CITY OF PORTLAND, MAINE  
DEVELOPMENT REVIEW APPLICATION  
PLANNING DEPARTMENT PROCESSING FORM  
DRC Copy

Project Name/Description

TO: Inspections  
FROM: Jay Reynolds, Development Review Coordinator *JR*  
DATE: June 23, 2003  
RE: C. of O. for #35 Tidemill Road  
Lead CBL (212-A-048) ID# (2001-0280)

**From:** Jay Reynolds  
**To:** occupancy routing list  
**Date:** Wed, Aug 14, 2002 11:32 AM  
**Subject:** 35 tidemill rd. amendment

Amara EI Lot 15 Tide Mill Road
Grading, Drainage, Layout and Utilities Plans
<b>EER</b> Environmental Engineering & Remediation, Inc. 222 St. John Street, Suite 314 Portland, Maine 04102
Scale: 1" = 20'

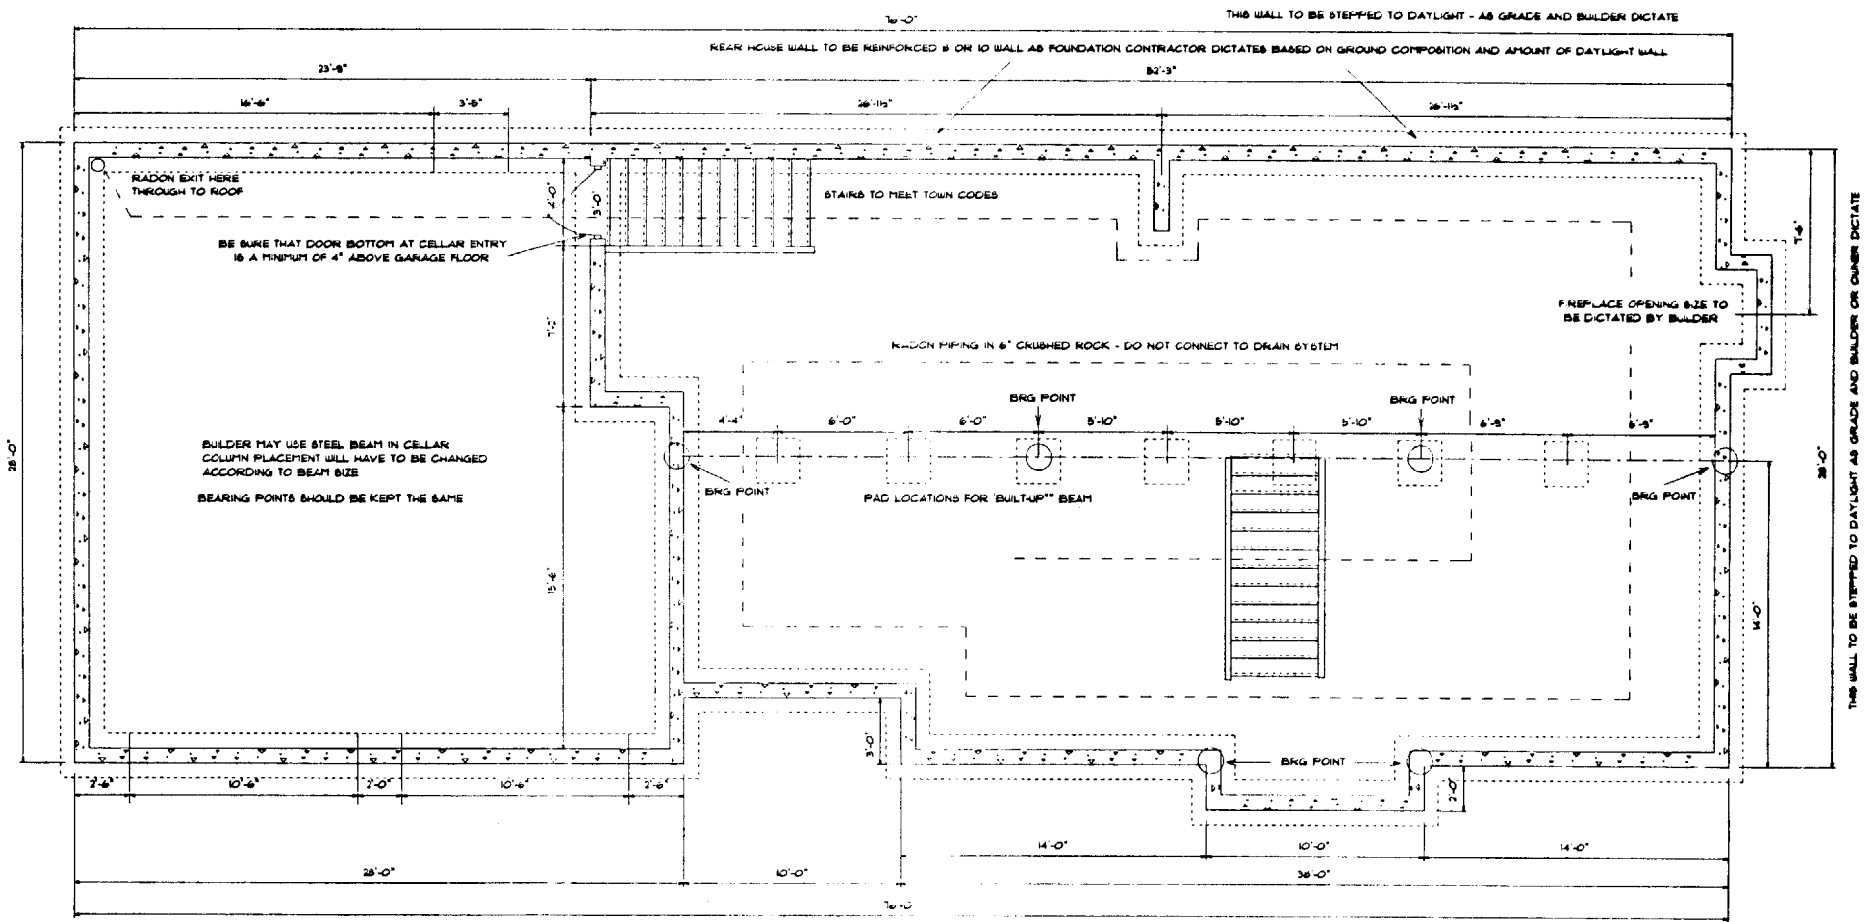
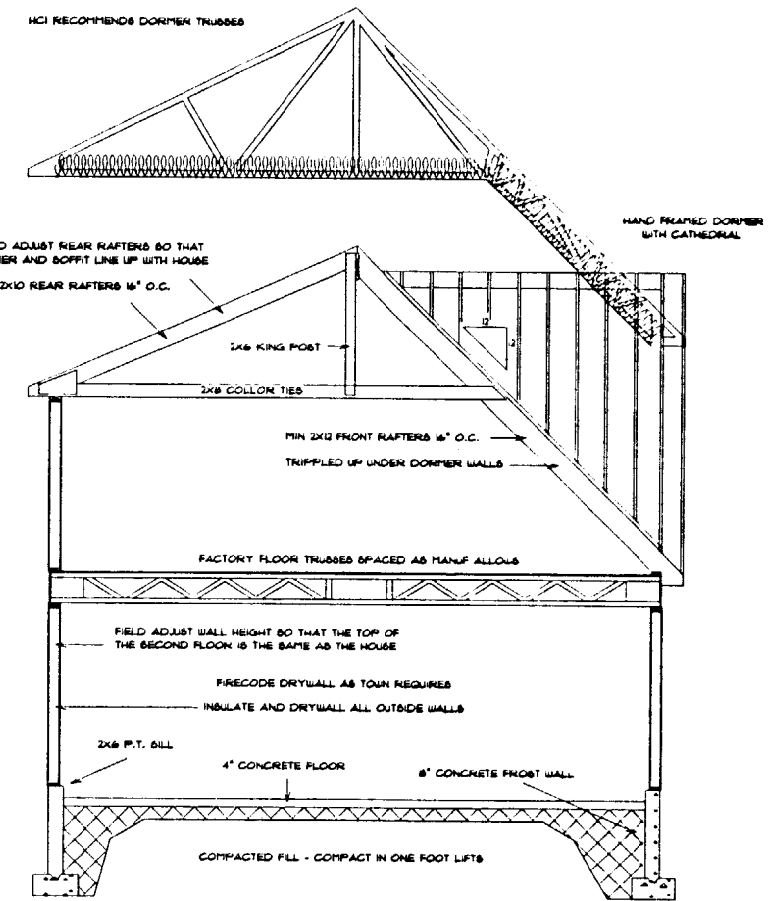
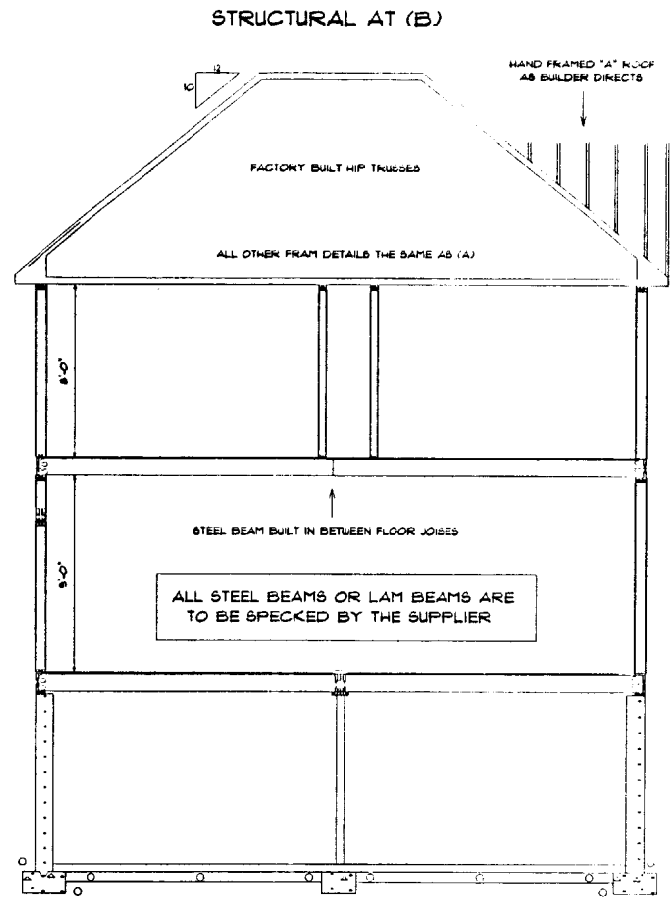
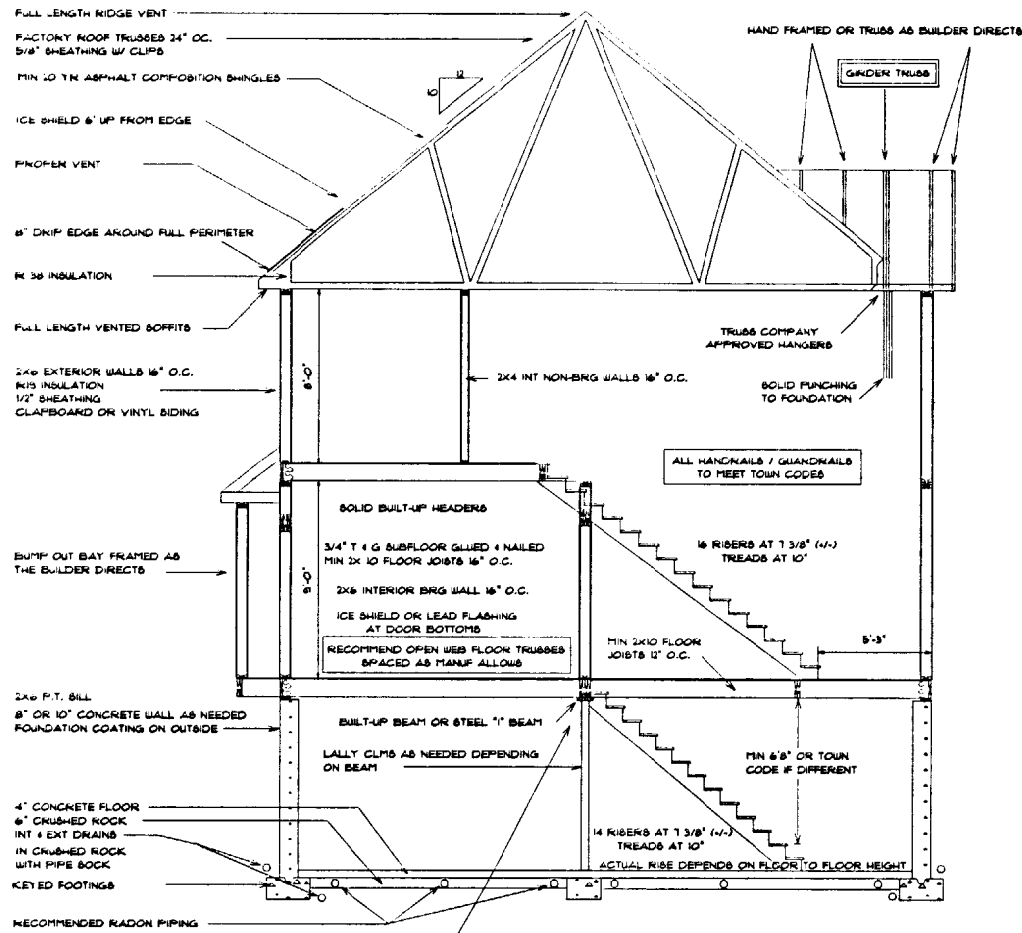
- 1 GRADING ALONG PROPERTY LINE ADJACENT TO #28 SHALL BE DONE SO THAT DRAINAGE FLOWS TOWARDS TIDE MILL ROAD, AS OPPOSED TO THE NEIGHBORING PROPERTY.
- 2 All damage to sidewalk, curb, street, or public utilities shall be repaired to City of Portland standards prior to issuance of a Certificate of Occupancy.

- 8 The building contractor shall check the subdivision recording plat for pre-determined first floor elevation and establish the first floor elevation (FFE) and sill elevation (SE) to be set above the finish street/curb elevation to allow for positive drainage away from entire footprint of building.

- 9 The site contractor shall establish finish grades at the foundation, bulkhead and basement windows to be in conformance with the first floor elevation (FFE) and sill elevation (SE) set by the building contractor to provide for positive drainage away from entire footprint of building.

Mike,  
I did go out to take a look at the EI residence going up at 35 Tide Mill Road. The owner is proposing to create a daylight basement by dropping the grades. This amendment should not cause problems, as long as the site continues to drain towards Tide Mill Road.

Please consider this an approval for the amended site plan for 35 tidemill road.  
I have met with the owner(Amara El) and builder(Jim Messer) to look at this. a revision was submitted for this change, and I am all set with it.
